To Protect and Promote the Health and the Environment of the People of Kittitas County

To: All Staff
From: Environmental Health
Date: May 14, 2025
Subject: SP-25-00006

DEATHERAGE SHORT PLAT

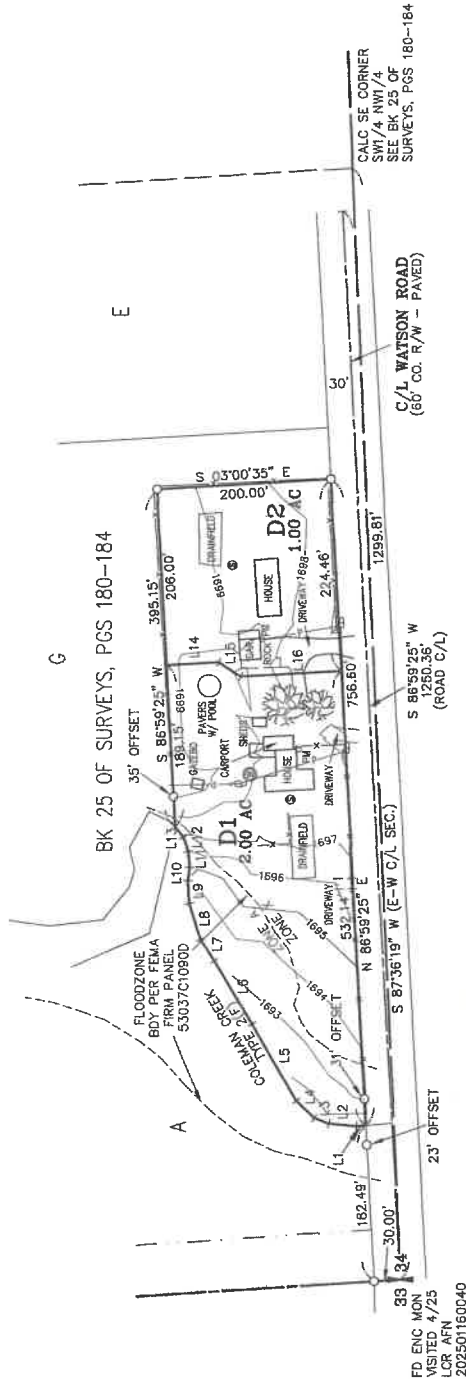
Drinking Water	<ul style="list-style-type: none">• A subdivision with nonpublic wells must provide a 100-foot water supply protection zone for each existing and proposed well. This protection zone must fit within the lot lines, or a copy of a restrictive covenant must be provided to each property located partially or entirely within the protection zone.
Wastewater	<ul style="list-style-type: none">• The houses each have their own permitted 3-bedroom septic system. No requirements for wastewater.
